PLANNING APPLICATION CONSULTATION RESPONSE

Application Number:	3/2024/0060
Proposal:	Approval of details reserved by conditions 7 (Construction Traffic Management Plan) and 15 (Construction Surface Water Management Plan) of planning permission 3/2023/0305.
Location:	Land at former Higher Standen Farm (adj Swardean Way Valley Lane Higher Peak Crescent South Gate Broadfield Street) Pendle Road Clitheroe BB7 1PR

Lead Local Flood Authority Position

The Lead Local Flood Authority is currently **unable to recommend the discharge of condition 15** on planning decision 3/2023/0305 on the basis of:

Construction of the new drainage system following the enabling works

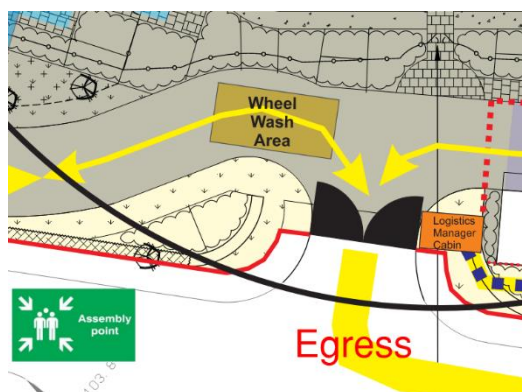
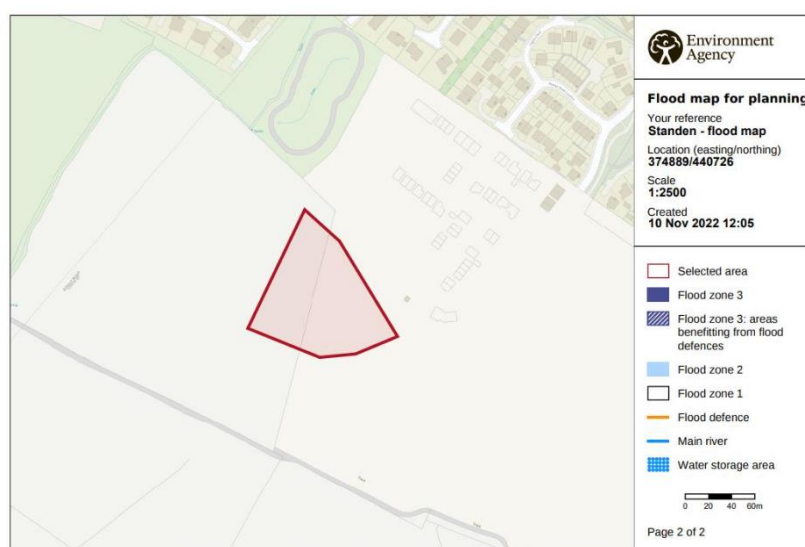
- The applicant has failed to provide sufficient information to demonstrate how surface water will be managed during the construction phase. The Lead Local Flood Authority acknowledges, the applicant's reference to installing the site drainage as soon as possible, however this does not address how surface water will be managed appropriately in the interim period before the drainage system has been fully implemented. For the avoidance of doubt the applicant should provide

evidence of how surface water will be effectively managed prior to the construction of the proposed drainage system.
